Recommendation Report for Planning Permission for Works or Extension to a Dwelling

REF NO: AW/101/25/HH

LOCATION: 8 Cherry Close
Aldwick
PO21 3BA

PROPOSAL: Re-submission of AW/299/24/HH - Demolition of the existing porch and detached garage. New rear/side flat roof extension, front porch extension. Conversion of the first floor roof space with new rear dormer. Installation of 2 x side windows.

PROPOSED ELEVATIONS

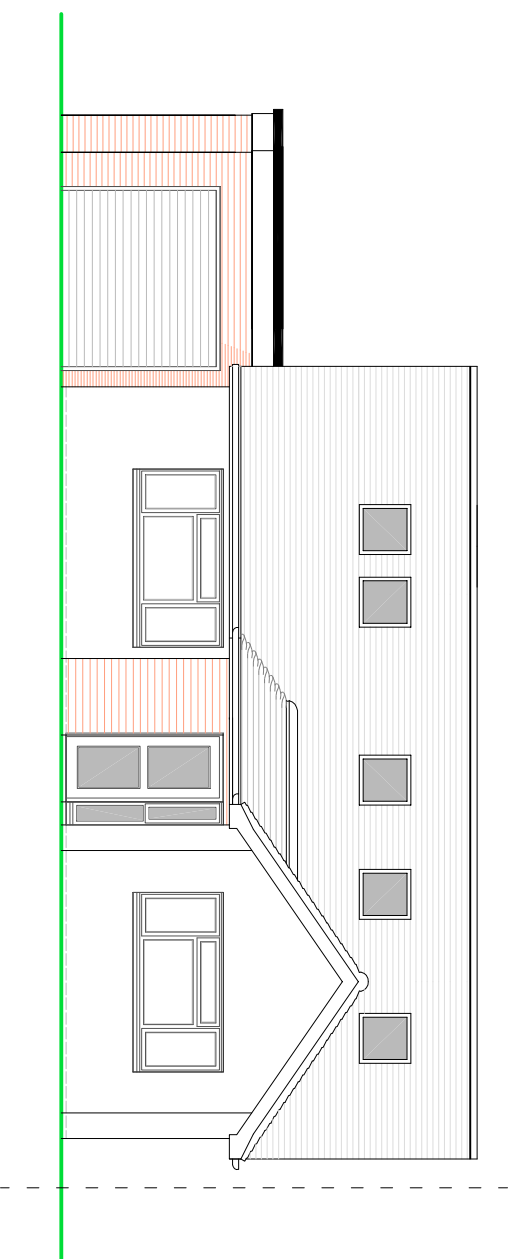
The site is a detached bungalow at the end of a cul-de-sac. At ground floor level, the alterations include wraparound rear extension with a replacement garage to the side of the property, and a small porch. The porch would replace an existing porch, increasing the depth in line with the existing front projection. The extension does not extend beyond the current furthest extent of the principal elevation. The porch has a crown roof and will be finished with materials to match those of the existing dwelling.

The proposed garage would be constructed close to the south western boundary and would measure approx. 3m high. Although the garage will be visible above the boundary treatments, and the height of this element has been increased from the previous application, the height of the new garage is not excessive and will not result in overbearing or overshadowing to the neighbouring property to the south west. The proposed rear extension would not extend beyond the existing single storey rear projection, and as such, the rear extension would not result in any overbearing or overshadowing to neighbouring properties. The ground floor fenestration would have an outlook over the rear garden serving the host dwelling, and would not result in any overlooking. Whilst two windows are proposed within the north eastern flank elevation, given that these windows are sited at ground floor level and the existing boundary treatment, the proposed fenestration would not result in unacceptable overlooking.

PROPOSED ELEVATIONS

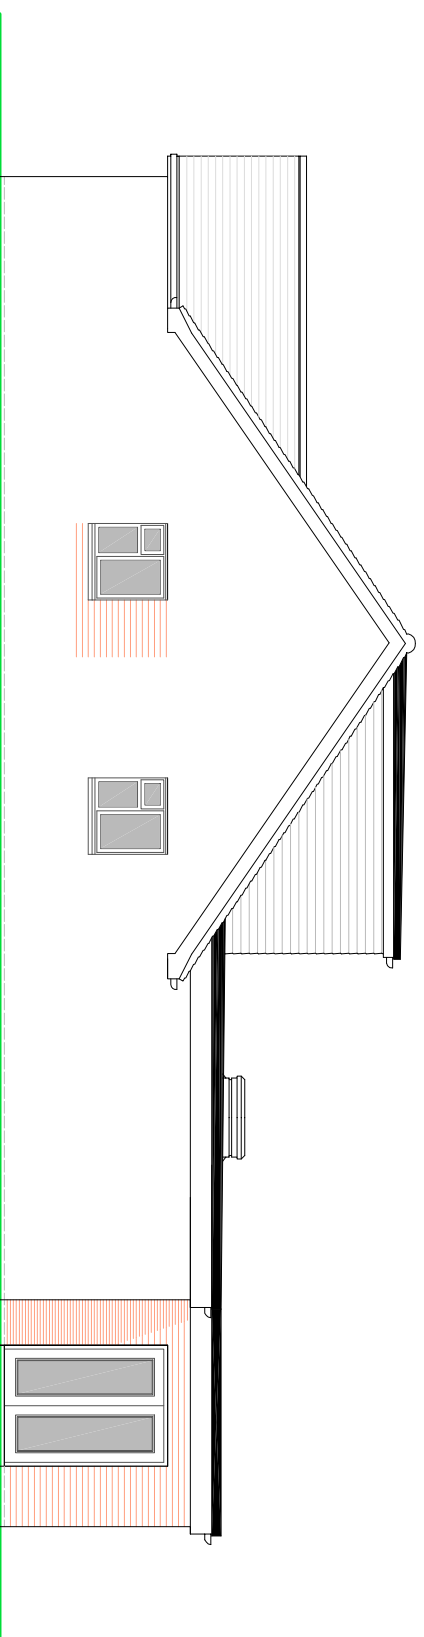
The rear extension is approx. 4.5m deep and it would extend the rear elevation level with the existing flat roofed projection to the rear of the property. The height of the rear extension element is 3m, matching the height of the existing rear projection. The rear extension will have minimal impact on the character and visual amenity of the property or surrounding area. The attached garage will project from the south western elevation and will be constructed following the demolition of an existing detached garage which is situated to the rear and side of the main dwelling. The width of the side extension is 3m, gradually widening to 3.9m at the rear. The proposed garage will extend an additional 3m beyond the rear elevation of the dwelling to accommodate a store and w/c to the rear. The height of this side extension element is to be increase under the current application, and will match the height of the rear extension, at 3m, where is was previously set down. This alteration will have a minimal impact on the appearance of the dwelling. The side and rear extensions do not unacceptably alter the scale and massing of the building and are acceptable in accordance with policy D DM4 of the Arun Local Plan. The side and rear extensions will be finished with brickwork to match the existing dwelling, helping the addition to integrate in accordance with policy D DM1 of the Arun Local Plan.

The rear dormer is 9.8m wide and adjoins the proposed rear extension. Although there are examples of other rear dormers on the street, the design of the dormer conflicts with the Arun Design Guide, which states that dormers should be minor incidents on the roof plane and incorporate a pitched roof in most cases. There is also partial conflict with policy D DM4 of the Arun Local Plan, as the dormer dominates the original roof form, due its width and height. However, it is noted that a large flat roofed dormer spanning the width of the roof could be achieved under permitted development, without the need for planning permission. Despite the policy conflict, the proposed dormer would not result in demonstrable harm to the character and appearance of the host dwelling so as to justify the refusal of planning permission. The dormer will be finished with cladding. Cladding is not currently present on the dwelling, and houses along Cherry Close tend to be finished with a mixture of brick and render. However, the material will be located to the rear of the dwelling and will not be visible in the street scene.

As part of the current application, there are several alterations to fenestration. This includes as additional window to be added to the south western elevation at ground floor level, the removal of a window to the store of the rear elevation and the replacement of the single glazed door on the north eastern elevation with a set of patio doors. These alterations will not impact the character of visual amenity of the dwelling and are acceptable in accordance with policies D DM1 and D DM4 of the Arun Local Plan.

The proposed dormer is situated at first floor level. Whilst the roof extension will not give rise to overbearing or overshadowing effects, the dormer introduces fenestration to the rear elevation at first floor level, which previously had no fenestration. Two windows are proposed, one with three casements and one with two, in addition to a Juliet balcony. The proposed windows will result in some increased overlooking of neighbouring properties. However, given that a similar dormer could be installed under permitted development which would offer similar views, the proposed dormer would not result in such harm in terms of overlooking so as to justify the refusal of planning permission in this regard. There is also a substantial distance between the property and the rear boundary, which effectively mitigates overlooking impacts on the property to the rear.
